Appeal Decision

Appeal Ref: APP/T2350/A/2191626

Lanshaw Barn, Woodhouse Lane, Slaidburn, Clitheroe BB7 3AH

- The appeal is made under section 78 of the Town and Country Planning Act 1990 against a refusal to grant planning permission.
 - The appeal is made by Mr A Rigby against the decision of Ribble Valley Borough Council.
 - The application Ref 3/2012/0089, dated 19 January 2012, was refused by notice dated 21 September 2012.
 - The development proposed is conversion of barn to residential unit.
-

Proposed East Elevation

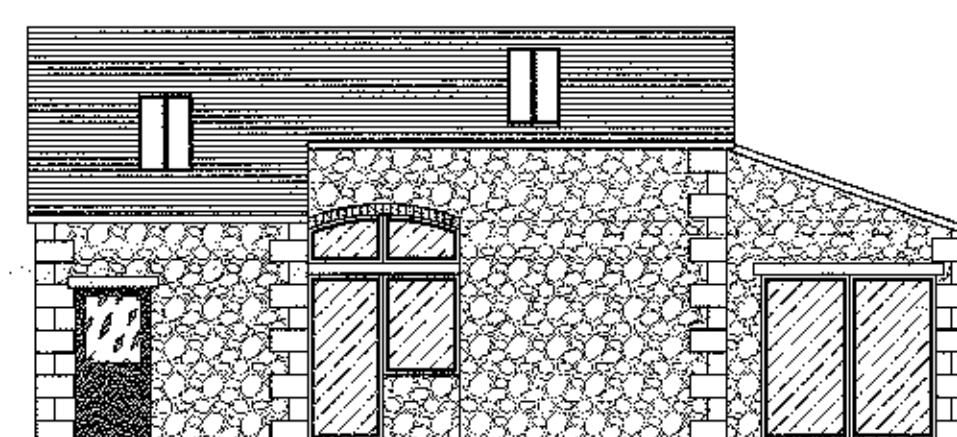
7. Furthermore, some of the detailing would not correspond with the style or character of the present building: this includes using an arched lintel over the main east elevation opening, where there is presently a straight lintel, the introduction of roof-lights, and a continuous range of windows in the north elevation which is unrelated to the original architecture of the barn, or any other vernacular building tradition in this locality. The character of the building would be changed from a simple, perhaps understated, vernacular stone barn with attached open storage bay into a dwelling of some substance.

Proposed Ground Plans

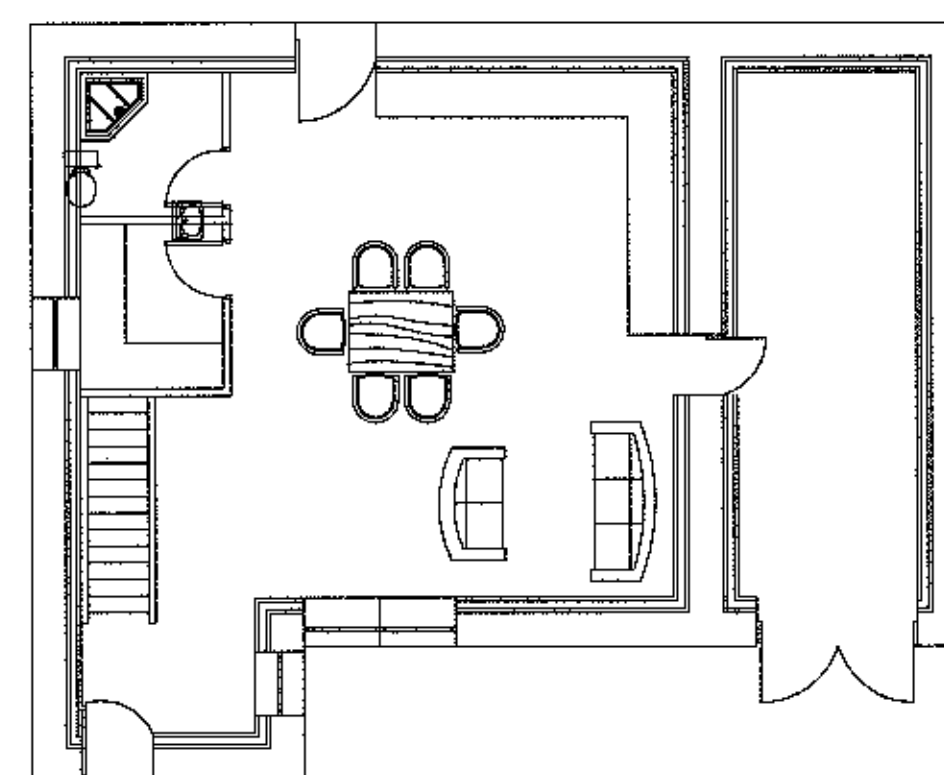
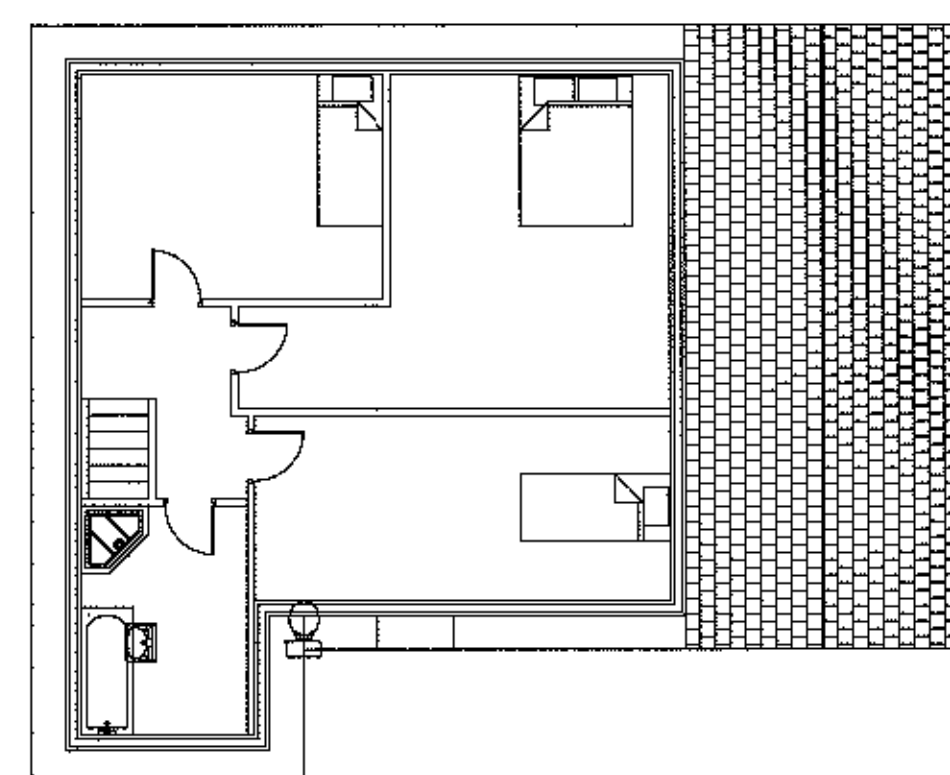
6. The proposed conversion would introduce considerable changes to both the appearance of this building and its surroundings. The building is suffering a degree of dereliction, the walls are damaged and an area of the roof has collapsed. With this degree of dereliction, the proposed scheme would require a considerable amount of reconstruction; possibly to the point where it would constitute an entirely new building. Although the proposed scheme would not result in any physical enlargement of the building, the works would re-open doors and window openings presently closed or unused, and introduce new windows and doors where none currently exist. The present open-fronted storage bay under the lean-to roof would be enclosed and incorporated into the living space of the dwelling.
